From: Gary Alford [REDACTED]
Sent: 19 February 2022 22:35
To: Harry Chalk <Harry.Chalk@arun.gov.uk>
Subject: Re: FG/17/22/HH, 44a Ocean Drive

SITE PLAN 1:500 @ A1

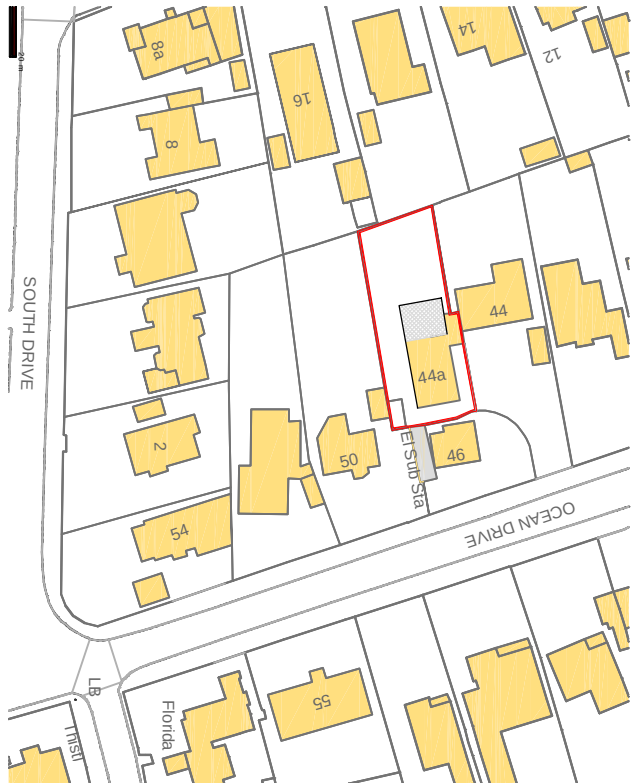
Additionally, I note the objection that has been submitted by a neighbour regarding the curtilage displayed on the site plans. The legal certificate attached to the application form refers to all land within the curtilage of the site plans as being owned by the applicant. From my visit yesterday and this objection I do have concerns as to whether the site plans do accurately show the correct curtilage. Could you confirm whether or not the correct curtilage is shown on the site plans? If not, could I request the site plans be amended and submitted within the week? By **25/02/22**. Many thanks.
